**Southern
Water**

Date
28/01/2022

Proposal: Approval of reserved matters (appearance, landscaping, layout and scale) following the grant of Y/91/17/OUT for 250 No dwellings with associated parking, road/footway/cycleway provision, open space, landscaping, surface water attenuation & ancillary works (resubmission following Y/152/20/RES). this site is not CIL Liable as in Yapton Strategic Site.

Site: Y/127/21/RES: - Land at Bilsham Road, Yapton, BN18 0LF.

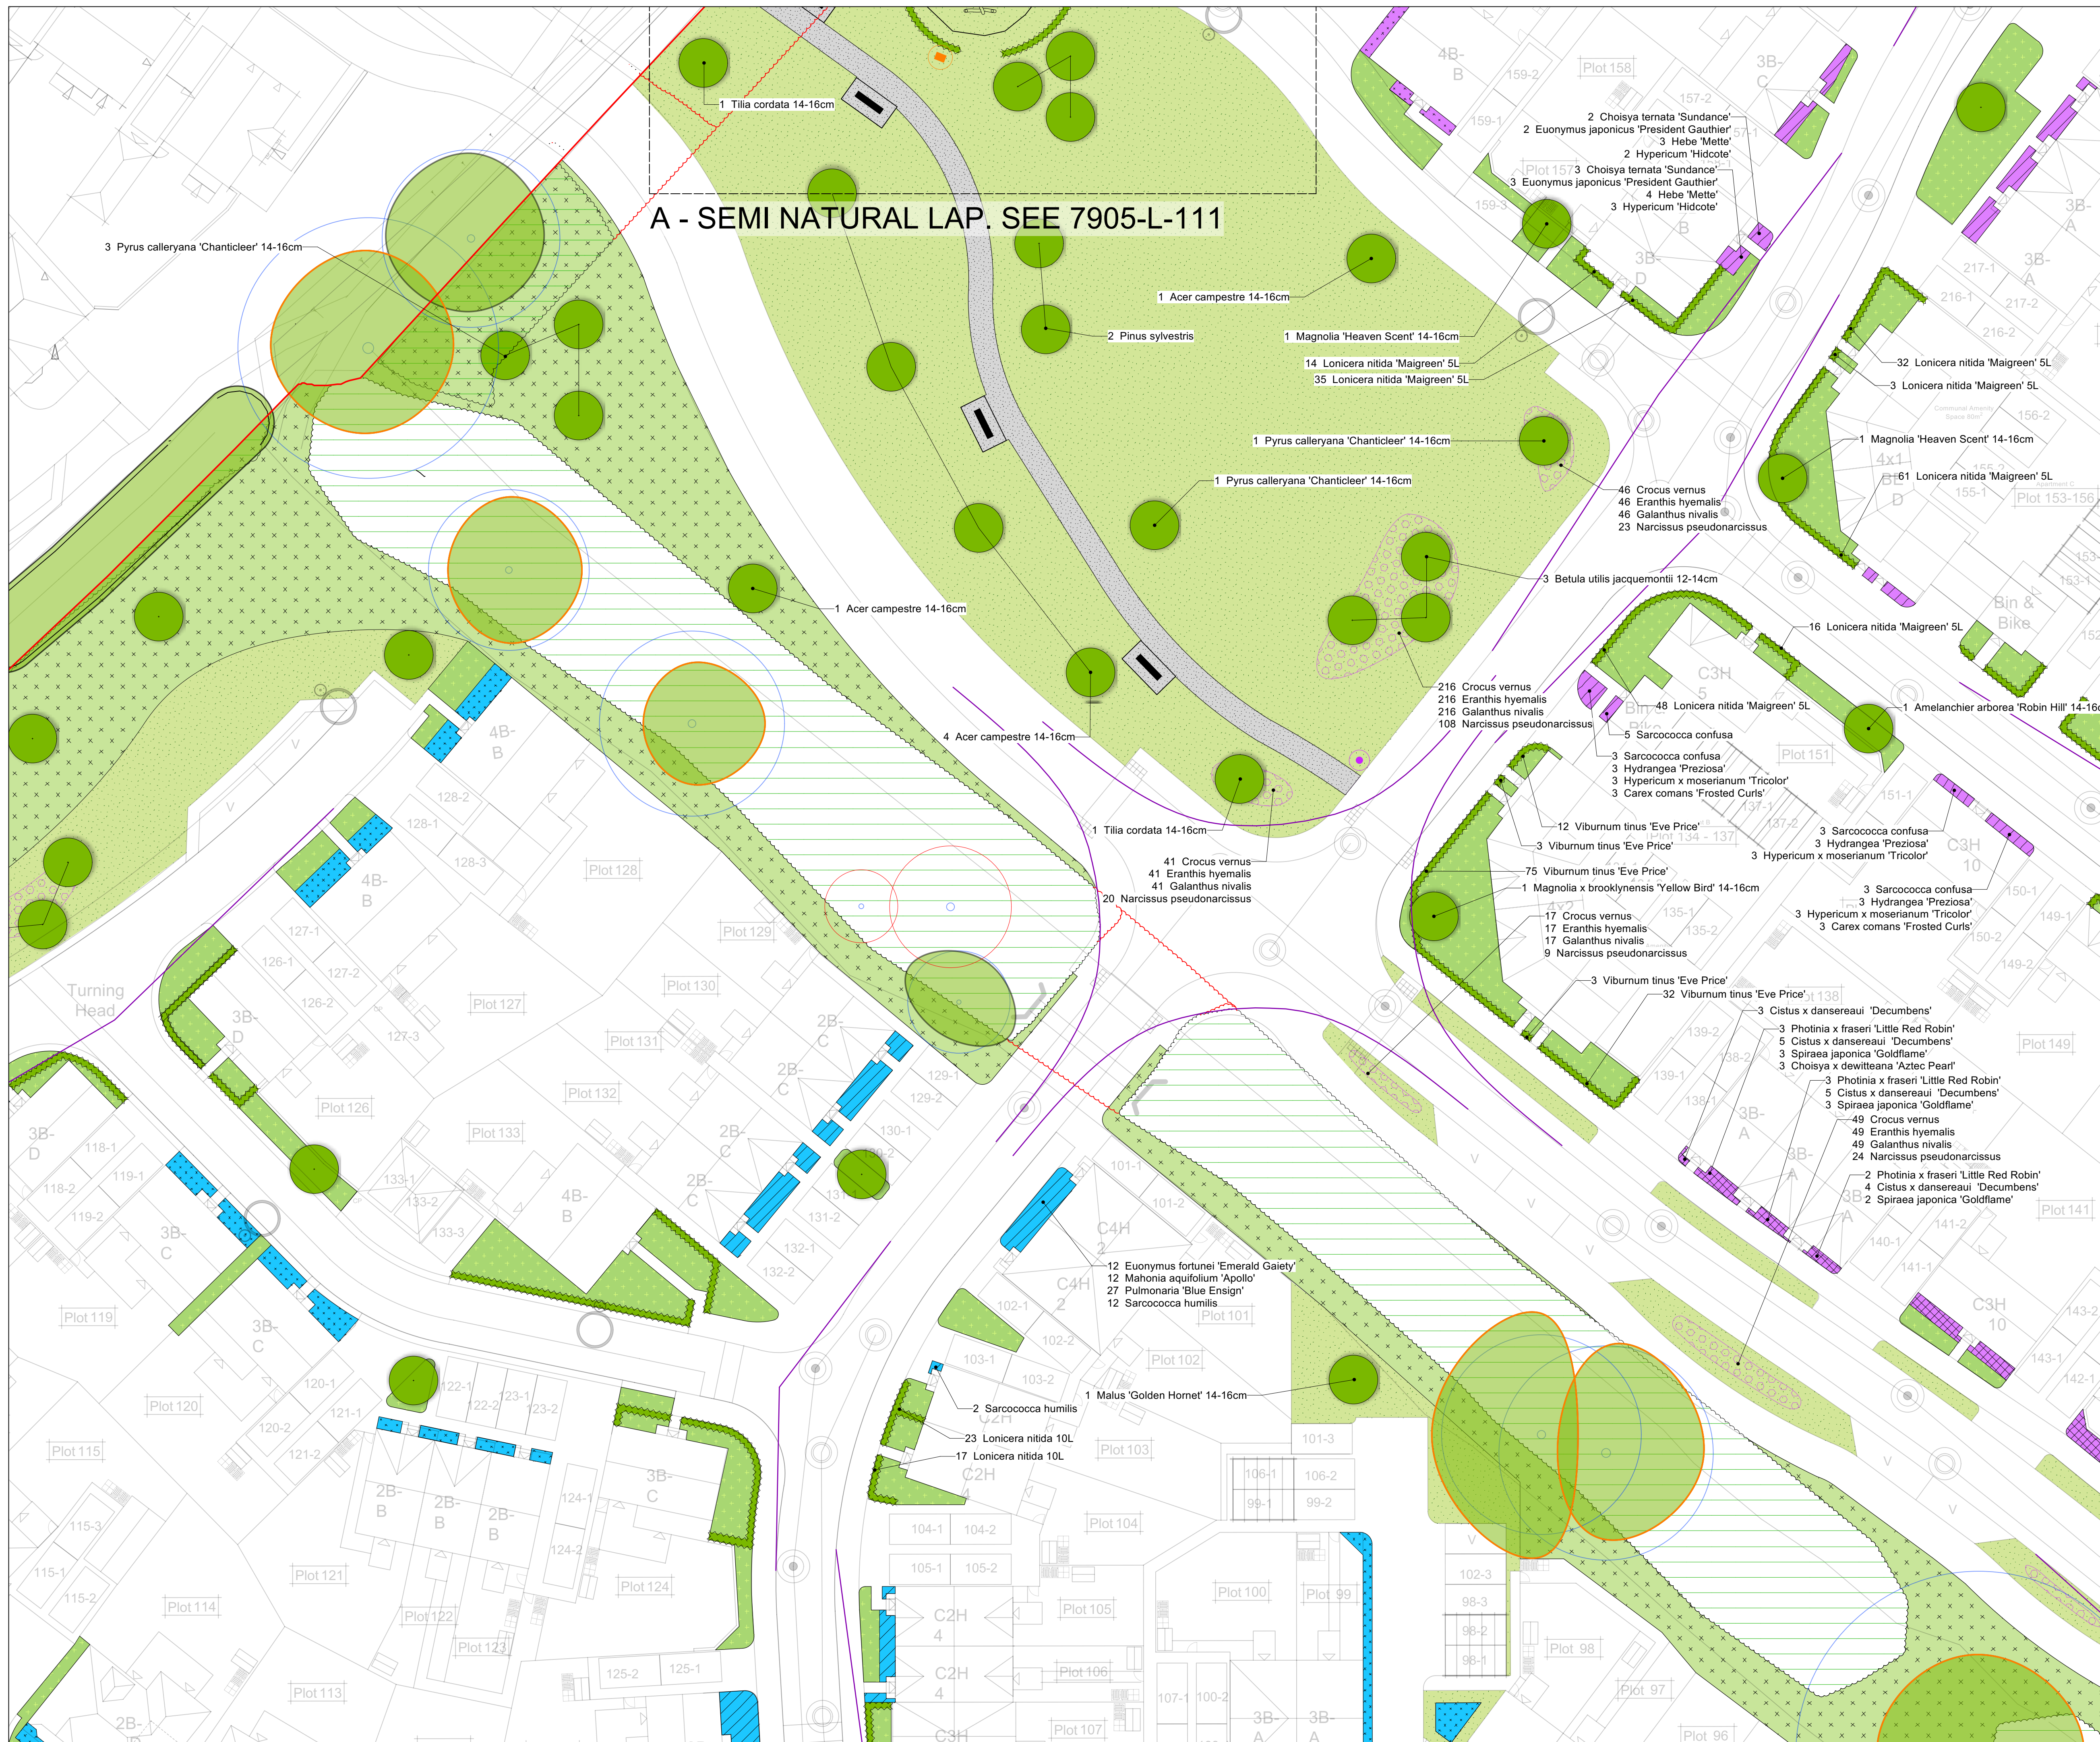
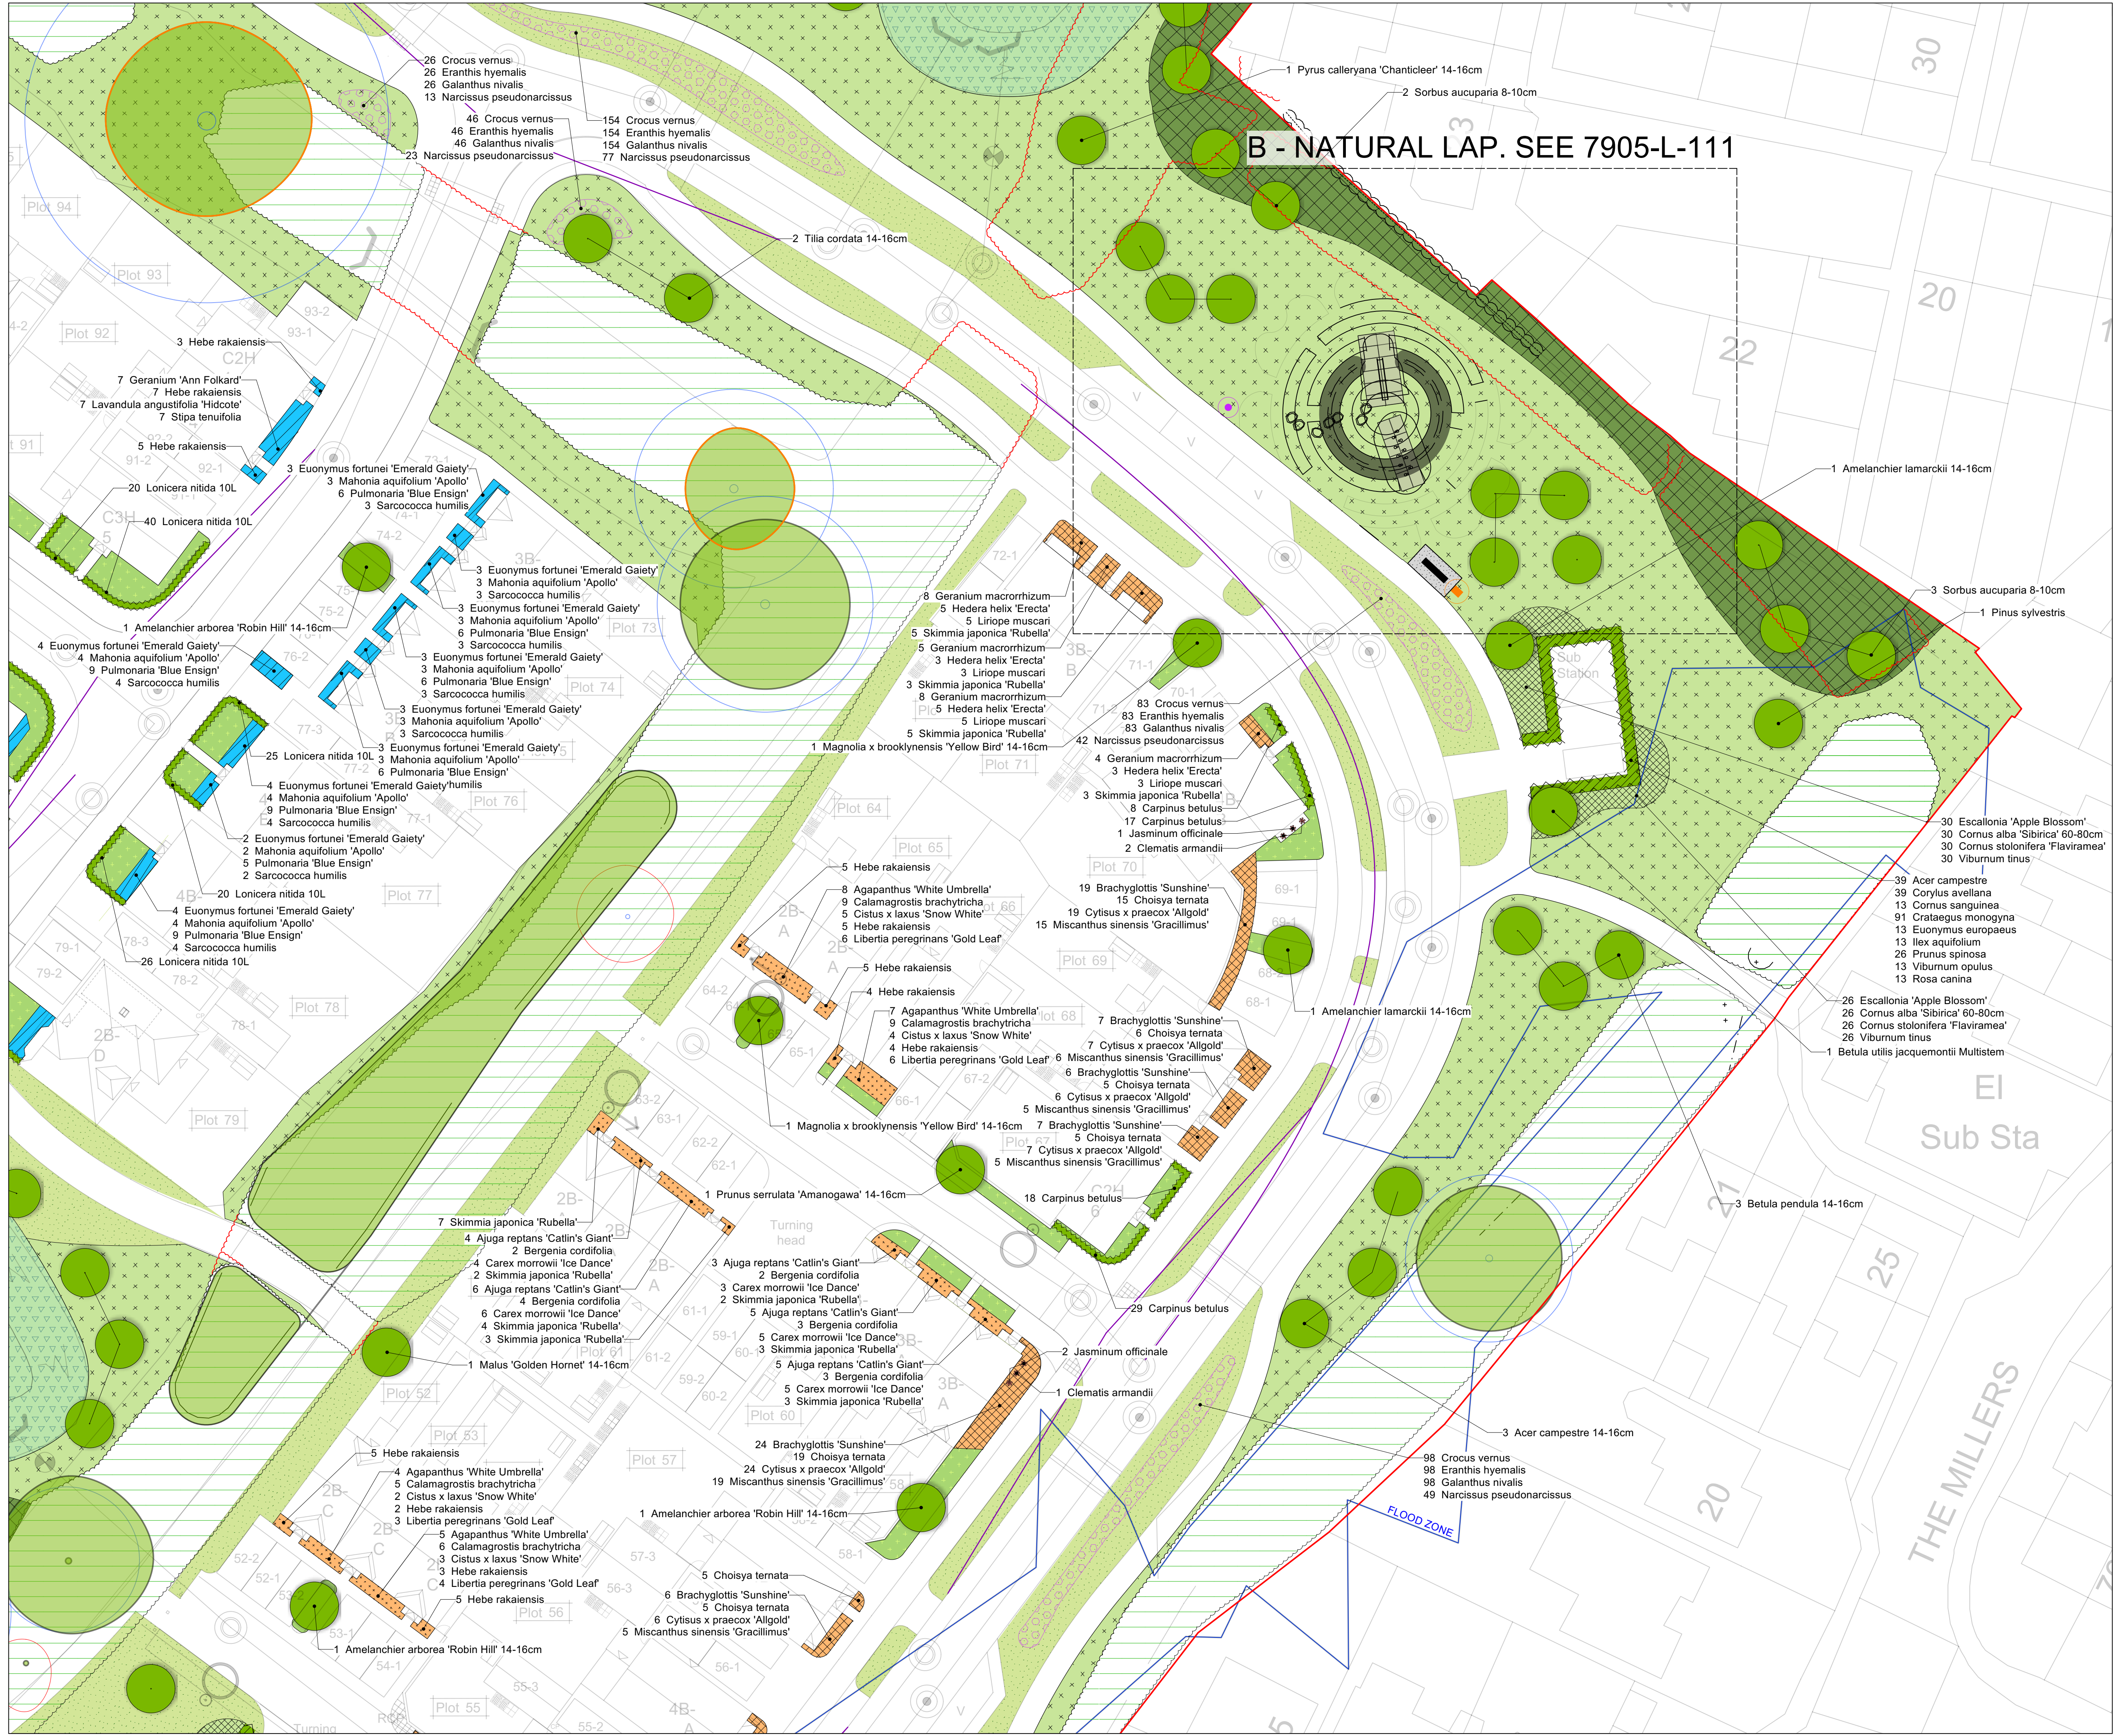
The submitted drawing indicates tree planting close to public surface water sewer. We have restrictions on the proposed tree planting adjacent to Southern Water sewers, rising mains or water mains and any such proposed assets in the vicinity of existing planting. Reference should be made to Southern Water's publication "A Guide to Tree Planting near water Mains and Sewers" (southernwater.co.uk/media/3027/ds-tree-planting-guide.pdf) and the Sewerage Sector Guidance (water.org.uk/sewerage-sector-guidance-approved-documents/) with regards to any landscaping proposals and our restrictions and maintenance of tree planting adjacent to sewers, rising mains and water mains.
